A303 Amesbury to Berwick Down

**8.9 Statement of Common Ground – Winterbourne Stoke Parish
Council**

**STATEMENT OF COMMON GROUND – Winterbourne Stoke Parish
Council**

Drawing Title
**RIGHTS OF WAY AND ACCESS
PLANS
REGULATION 5(2)(k) & 5(2)(o)
SHEET 5 OF 15**

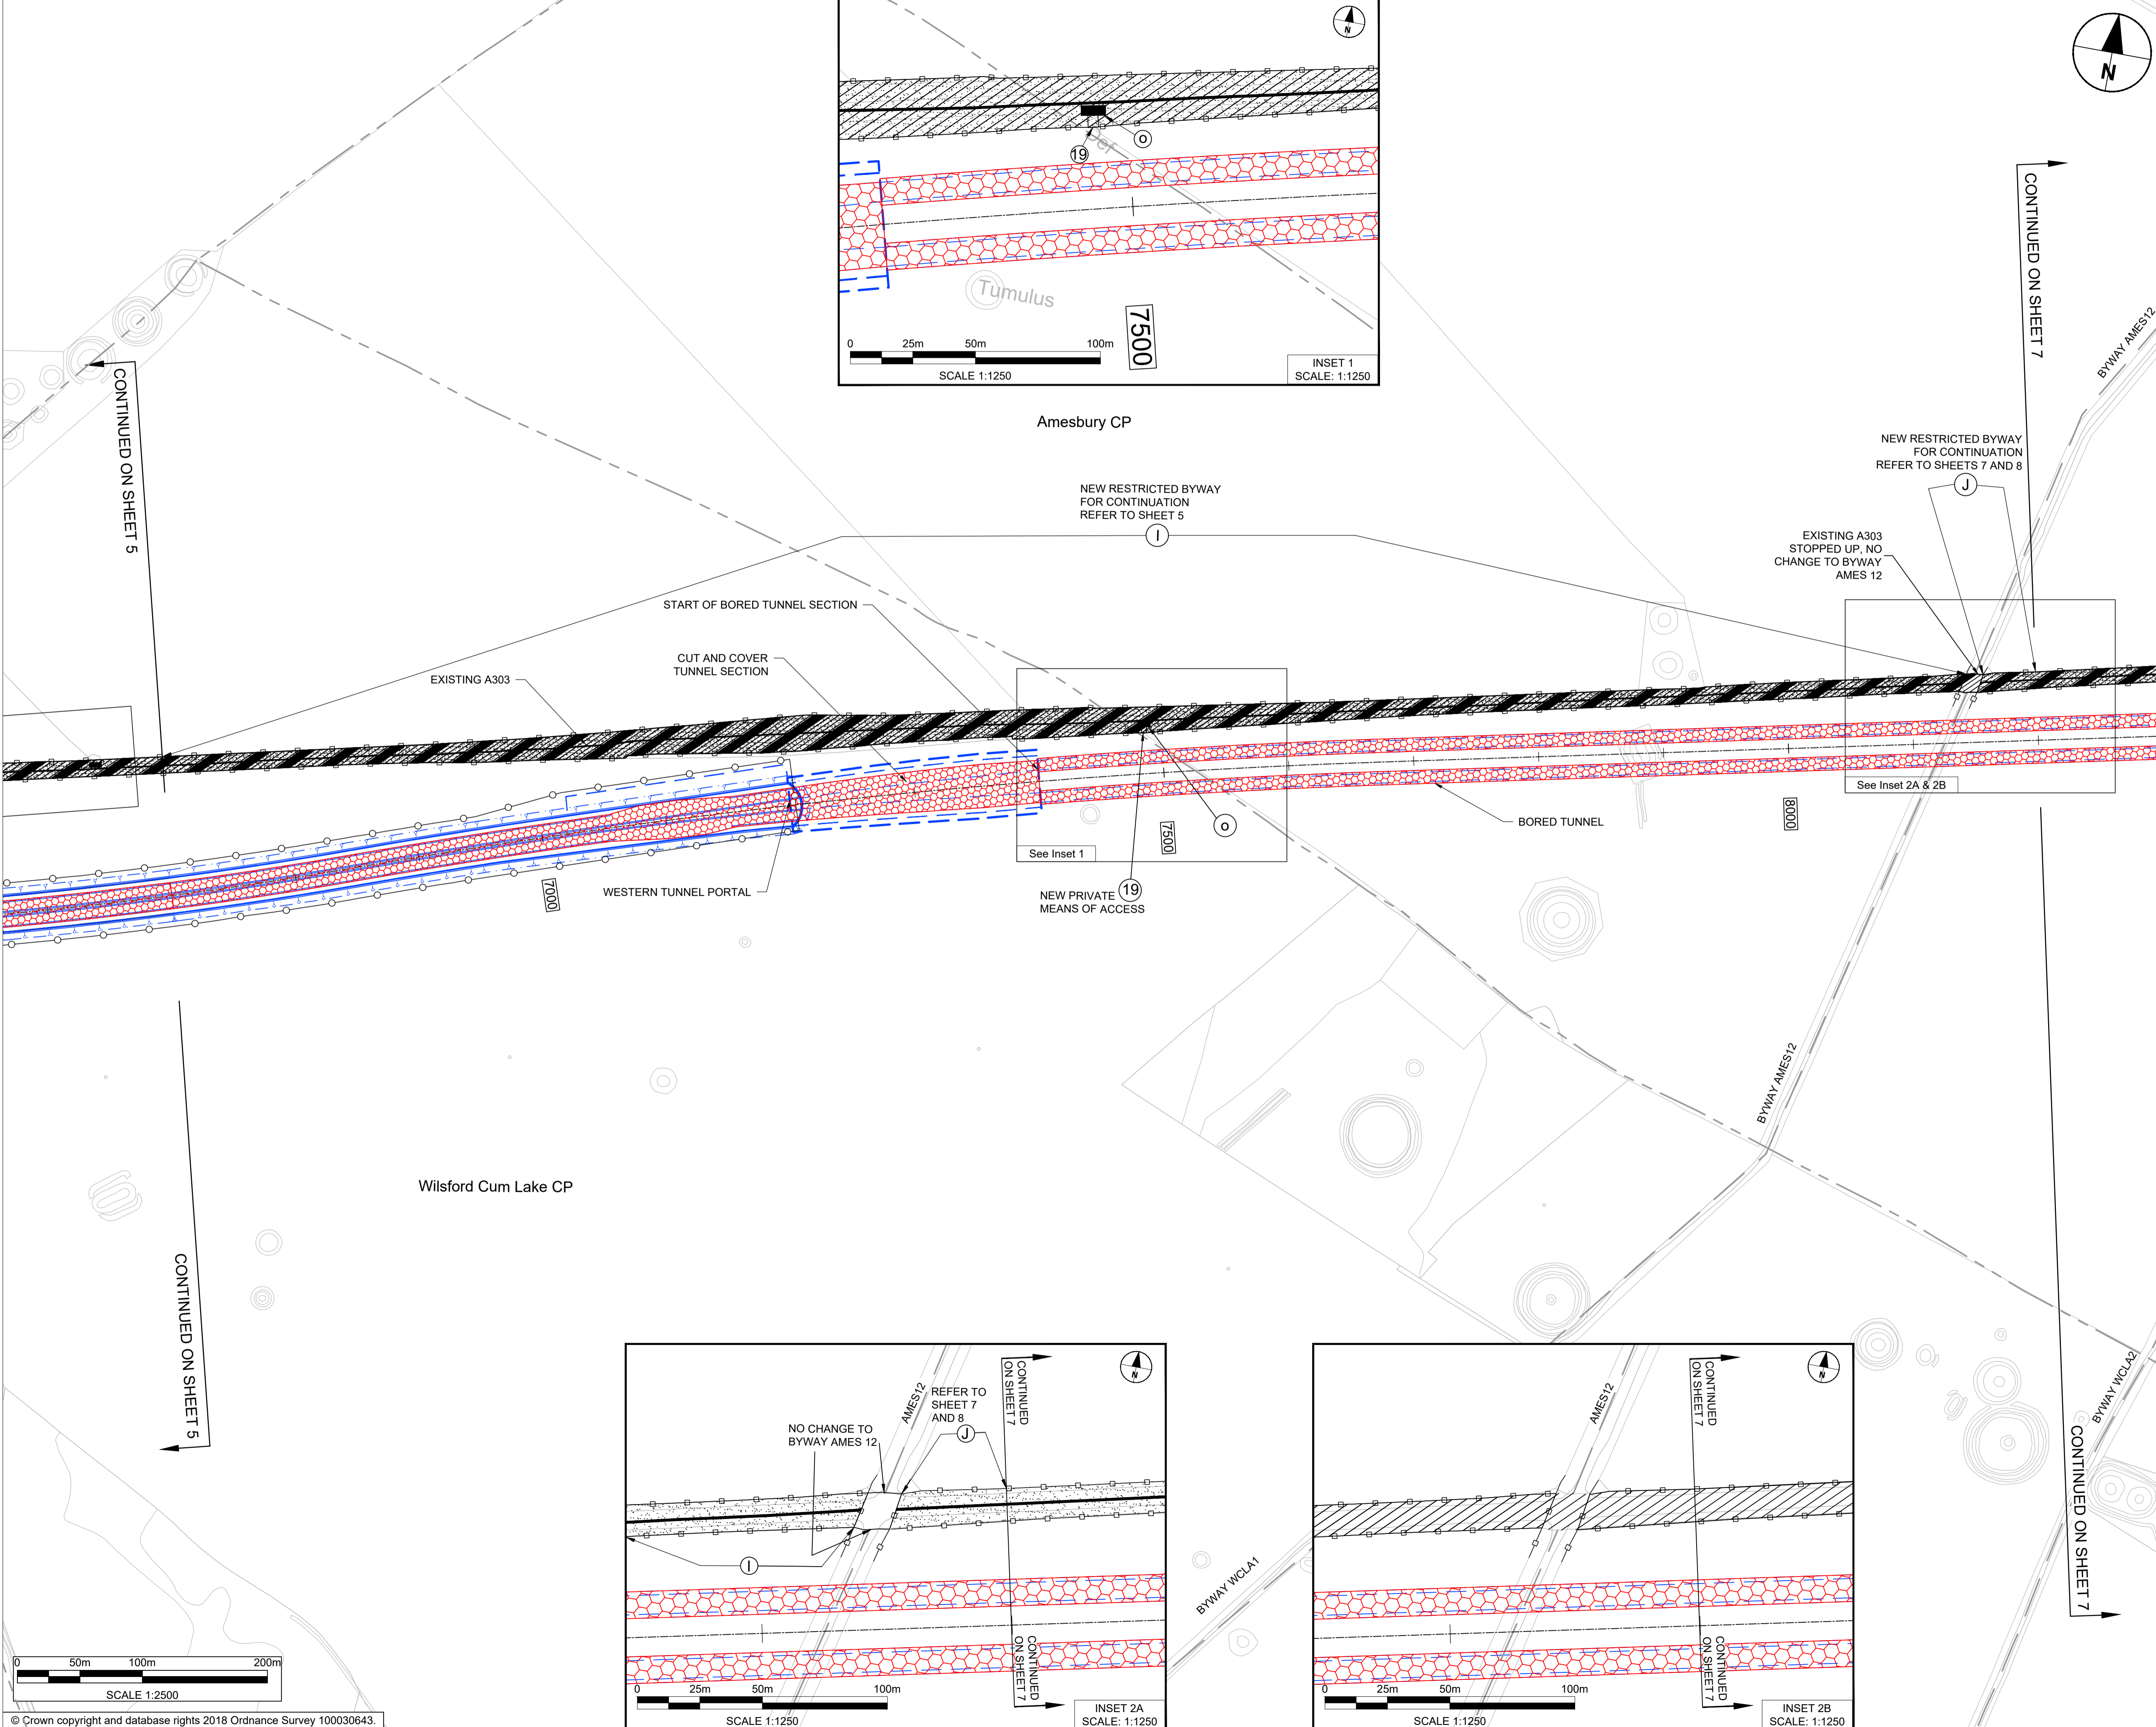
3.11	Longbarrow Junction and Agricultural Impact: access	-	Safe access should be provided to the fields to the east of the new Longbarrow roundabout and lying north and south of the new A303 and west of Green bridge No 4.	Private means of access to fields north and east of the new Longbarrow Junction would be provided and are shown on the Rights of Way and Access Plans [APP-009], sheets 5, 14 and 15.	Agreed
